Item No. **Report of the Head of Planning, Building Control, Sport & Green Spaces**

Address LAND ADJACENT TO 171 NORTH HYDE ROAD HAYES

Development: Erection of two storey building comprising ground floor shop, two bedroom flat at first floor level and associated parking (Part Retrospective)

LBH Ref Nos: **11980/APP/2015/1160**

DATE:
06/05/2015
SCALE:
1:100
DRAWING NUMBER:
171/UB34NS/003

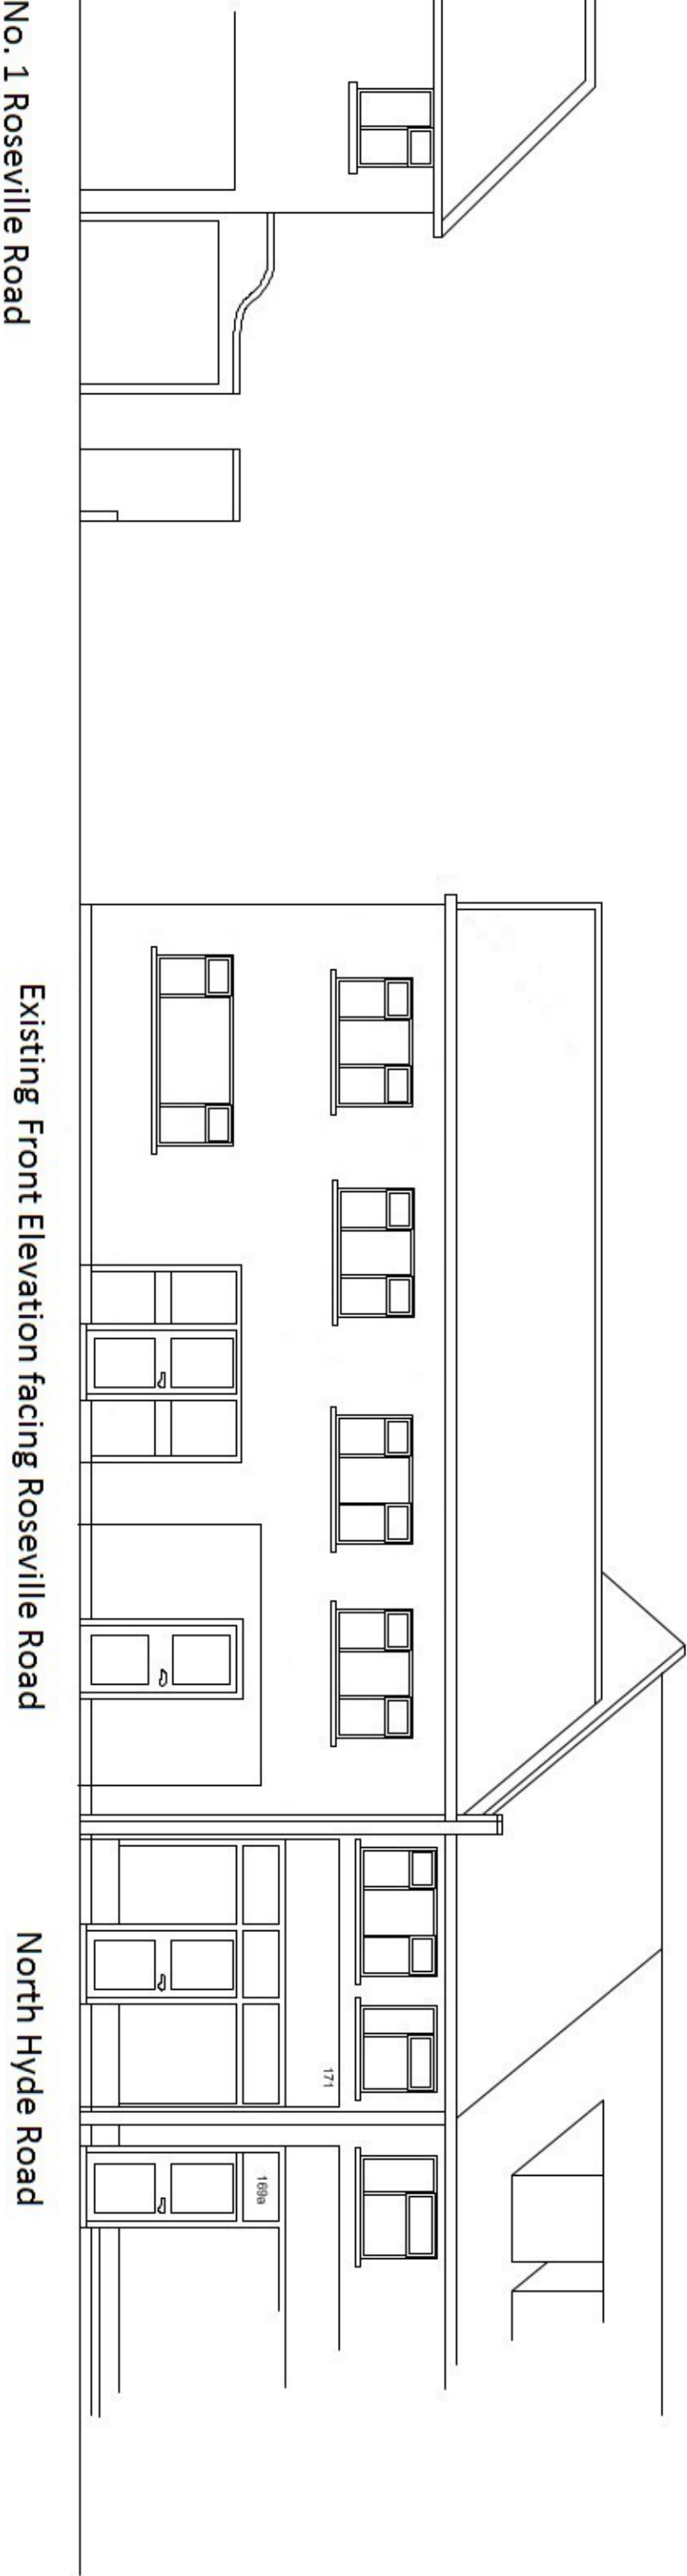
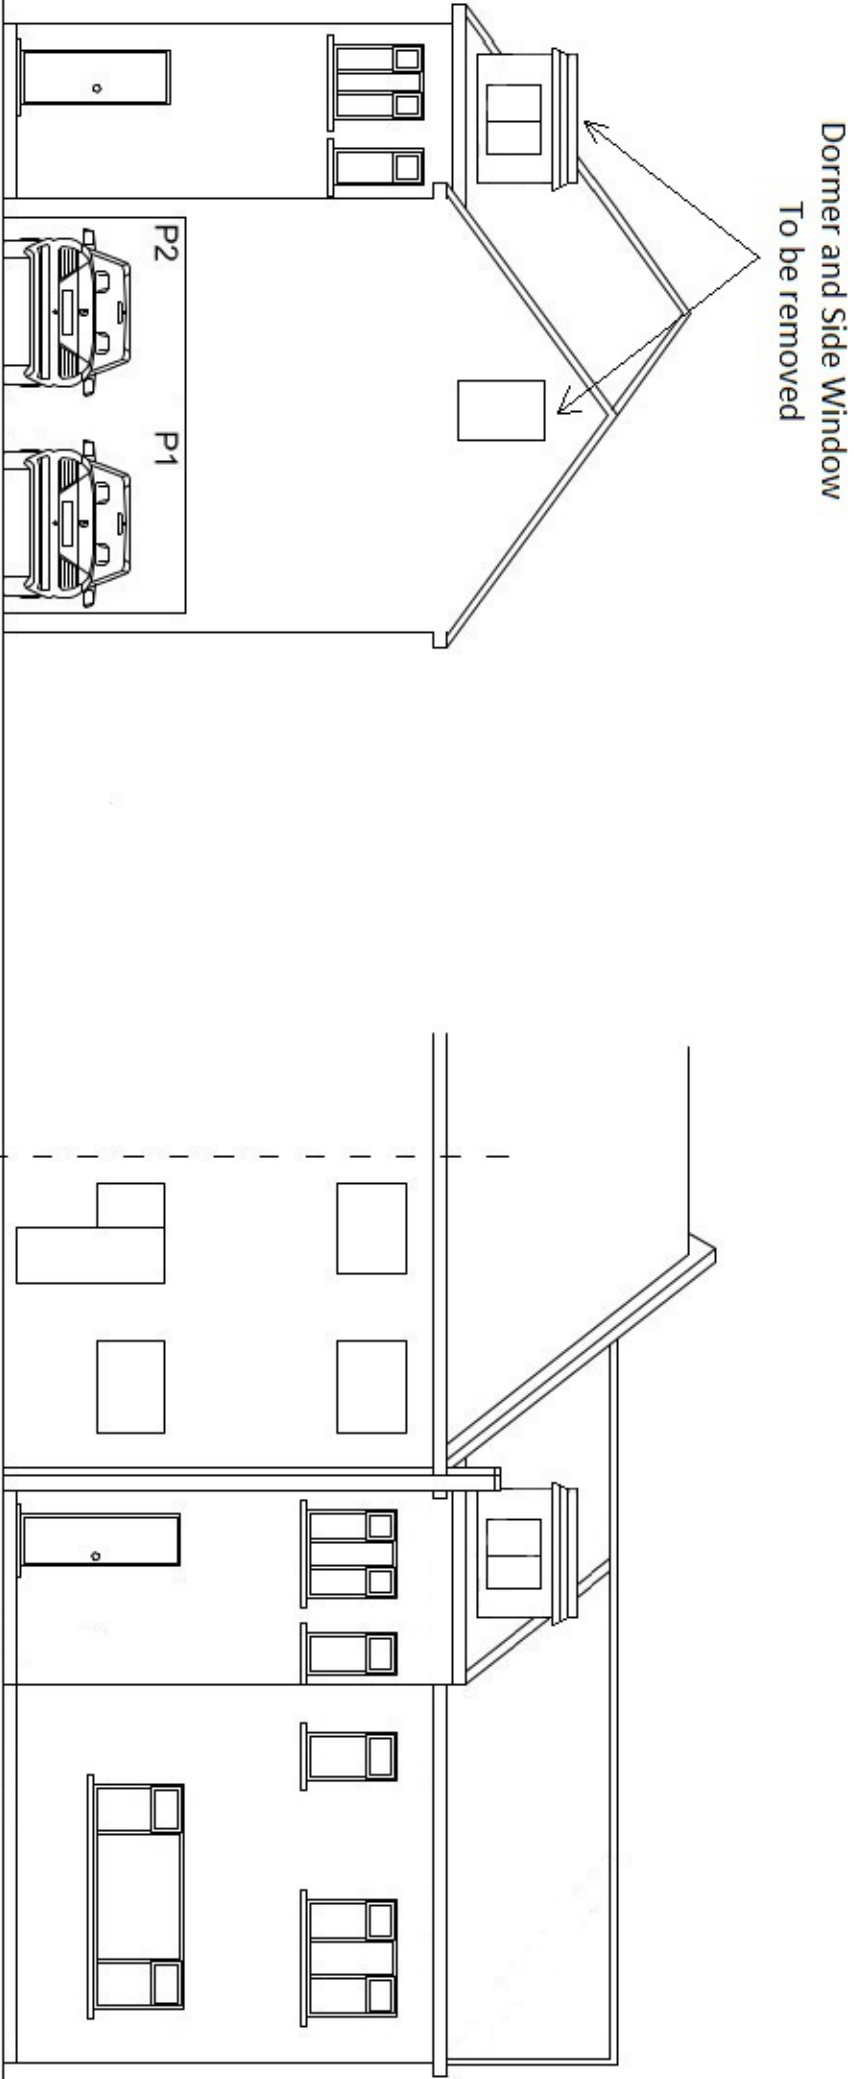
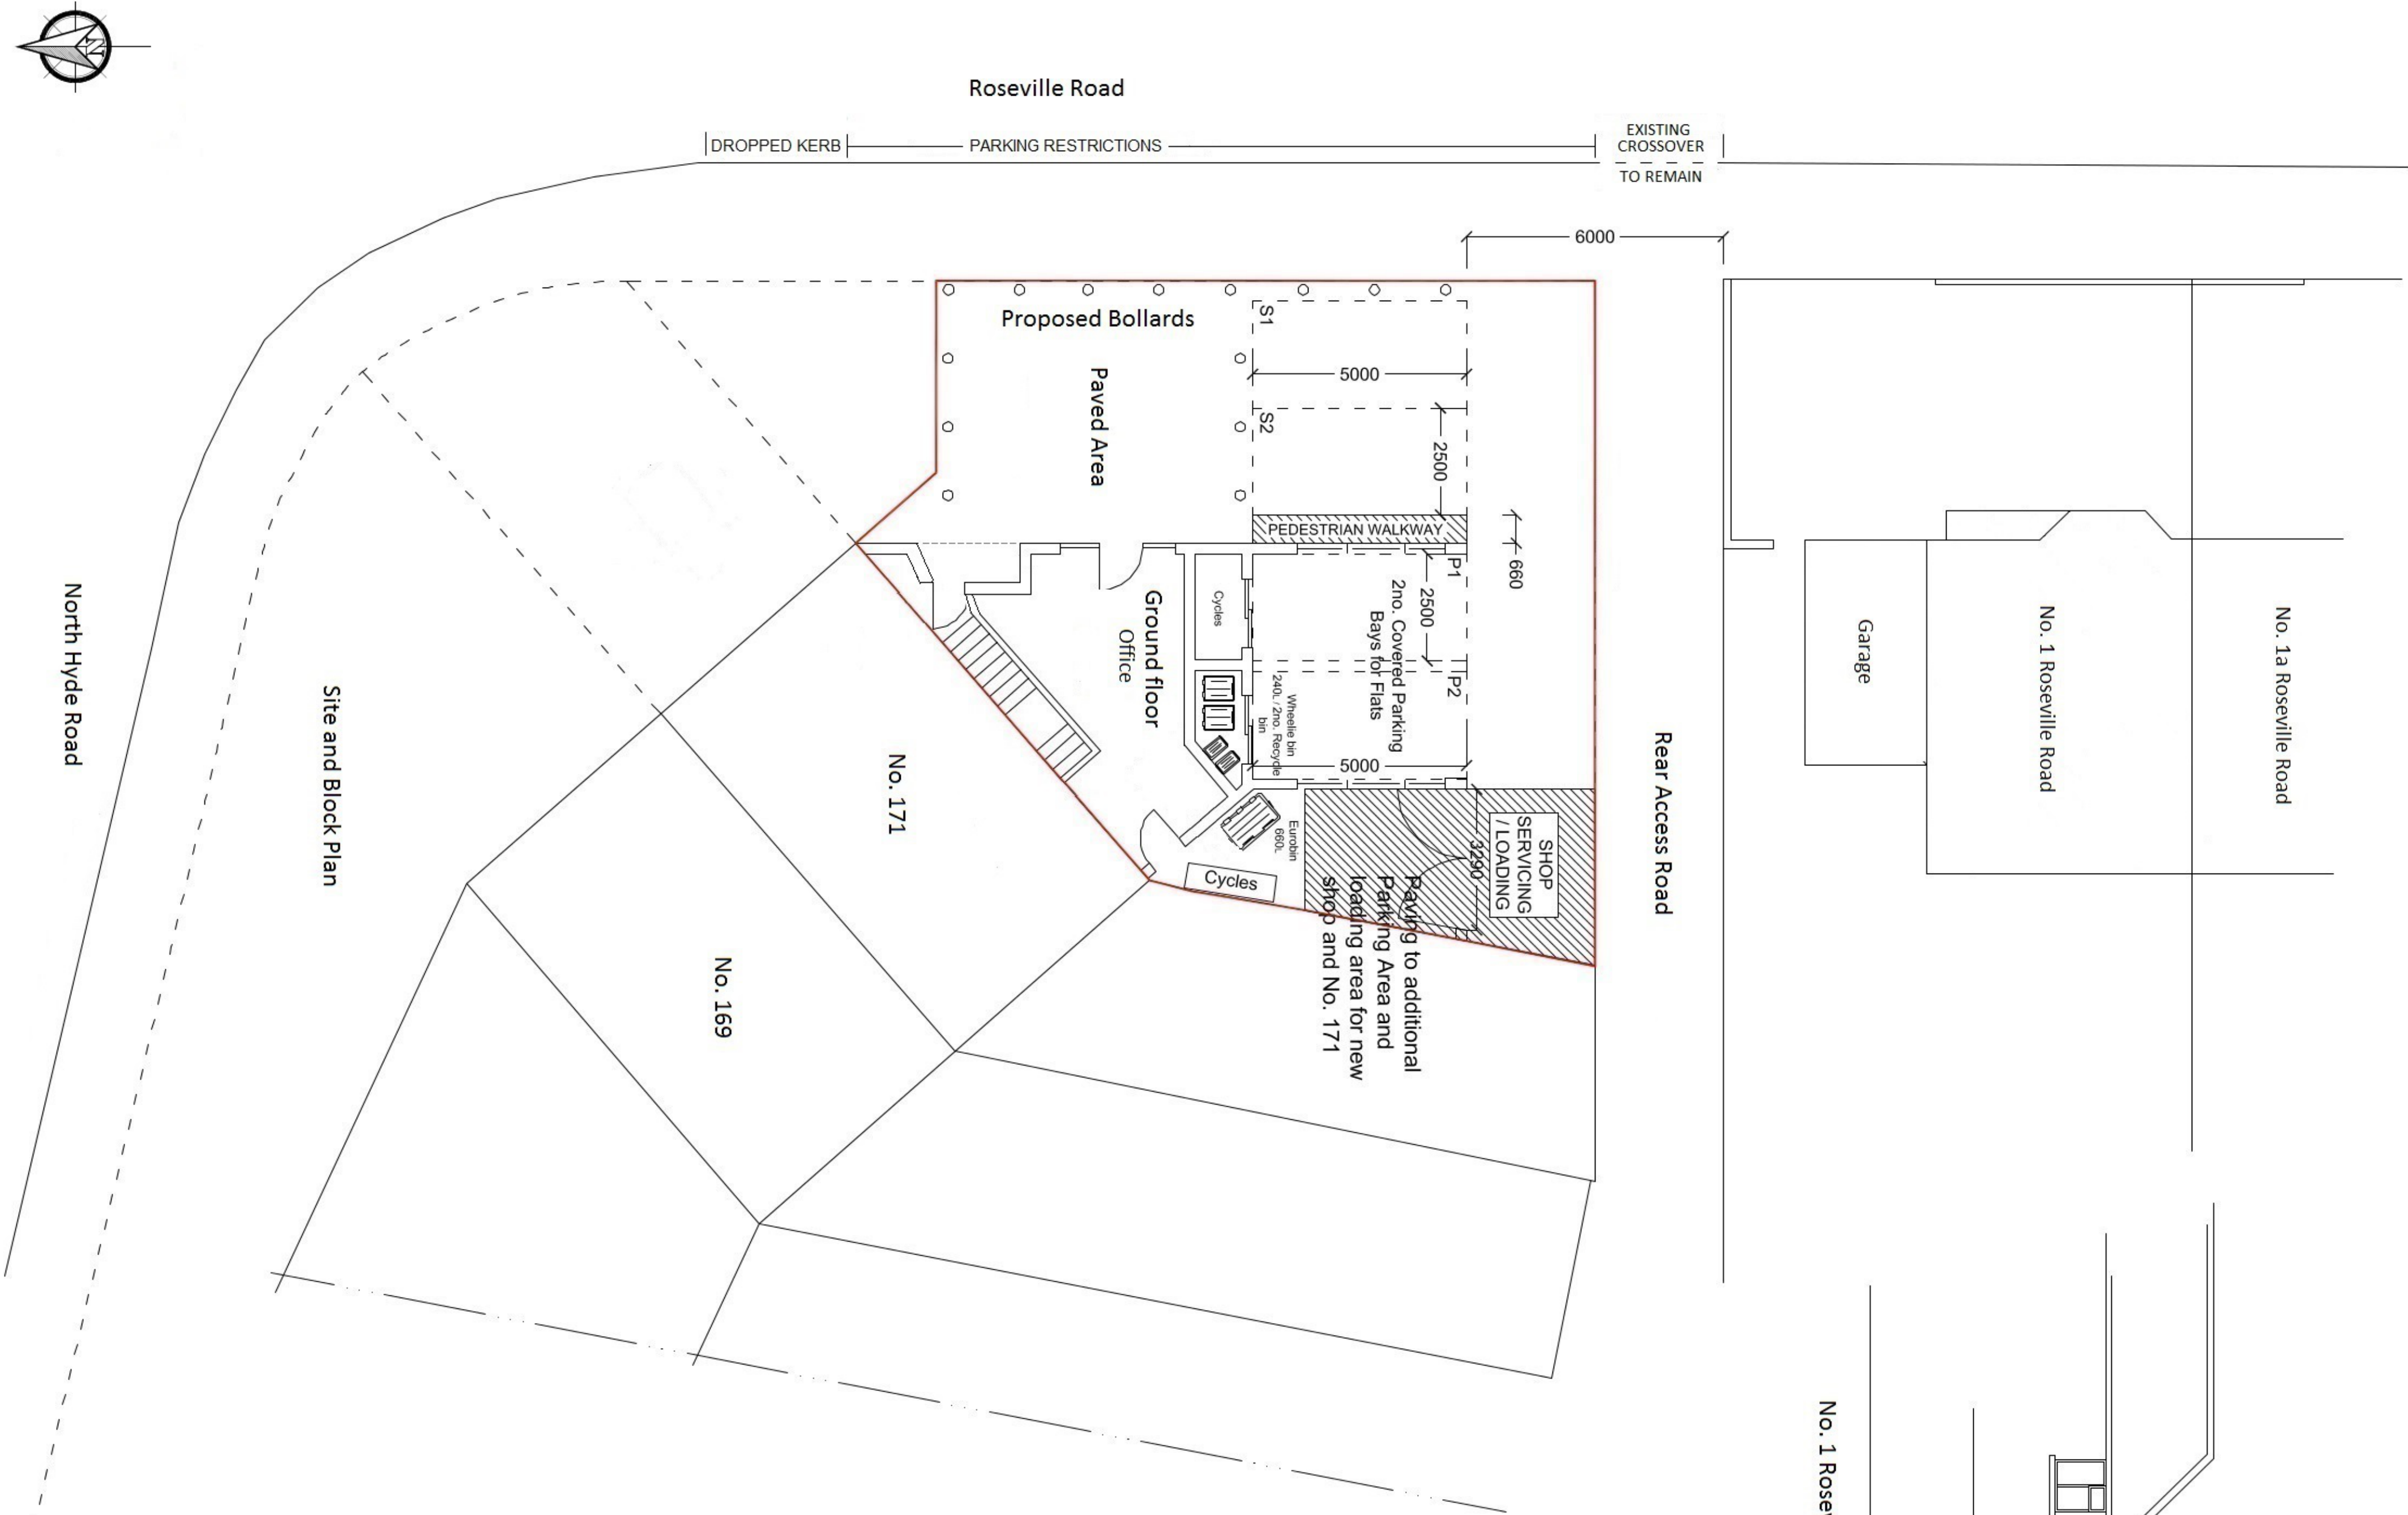
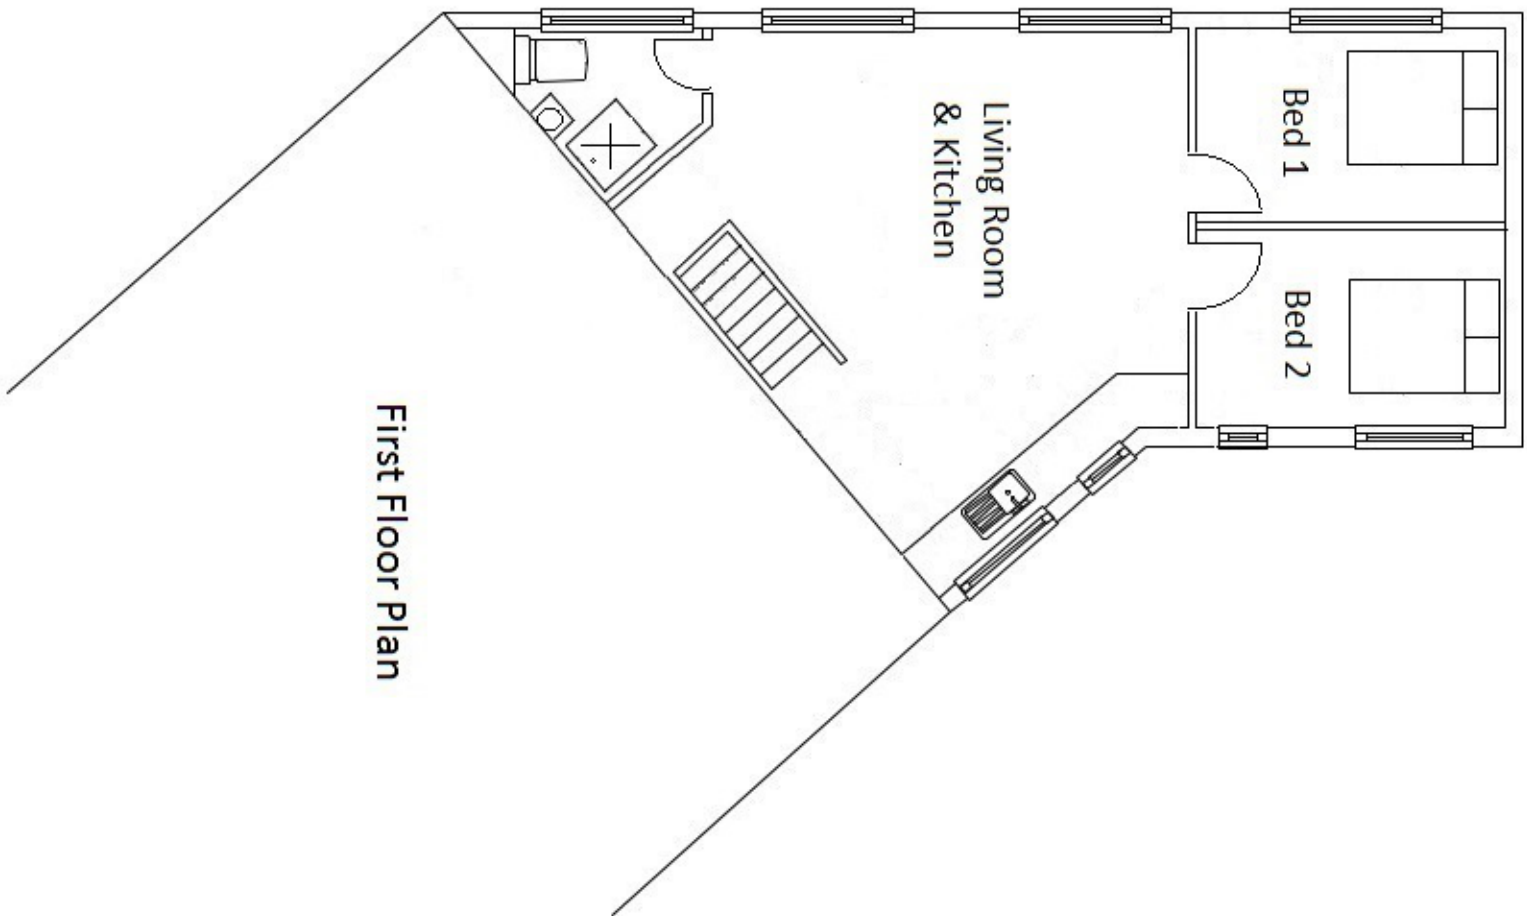
The application is a re-submission of a previously allowed scheme 11980/APP/2012/708 - granted permission on 28/05/2012). However the scheme built does not equate to the approved drawings and several unauthorised alterations were made. The existing plans show what has been built and the proposed plans now show what is acceptable to the LPA and these have taken several revisions. The scheme is recommended for approval subject to the revisions and the removal of the unauthorised rear dormer, first floor side gable window and the walls and gates around the car port.

The previous application provided 2 open ended car port spaces for 2 covered spaces for the first floor flat. On the sides of the car port was shown an open area with railings which provided visibility as well as security. this arrangement was approved. However, the applicant inserted windows into the areas where railings had been agreed and extended the carport with a 2m high wall on both sides to the service road installing timber gates effectively closing in the carport area. The applicant has stated that this is for security purposes as builders materials and equipment were constantly being stolen and also for the increased security of the future tenants.

However, the walls and the gates are considered to reduce visibility significantly when existing the carport and the Highways officer recommended a refusal based on highways grounds. In previous correspondence stating:
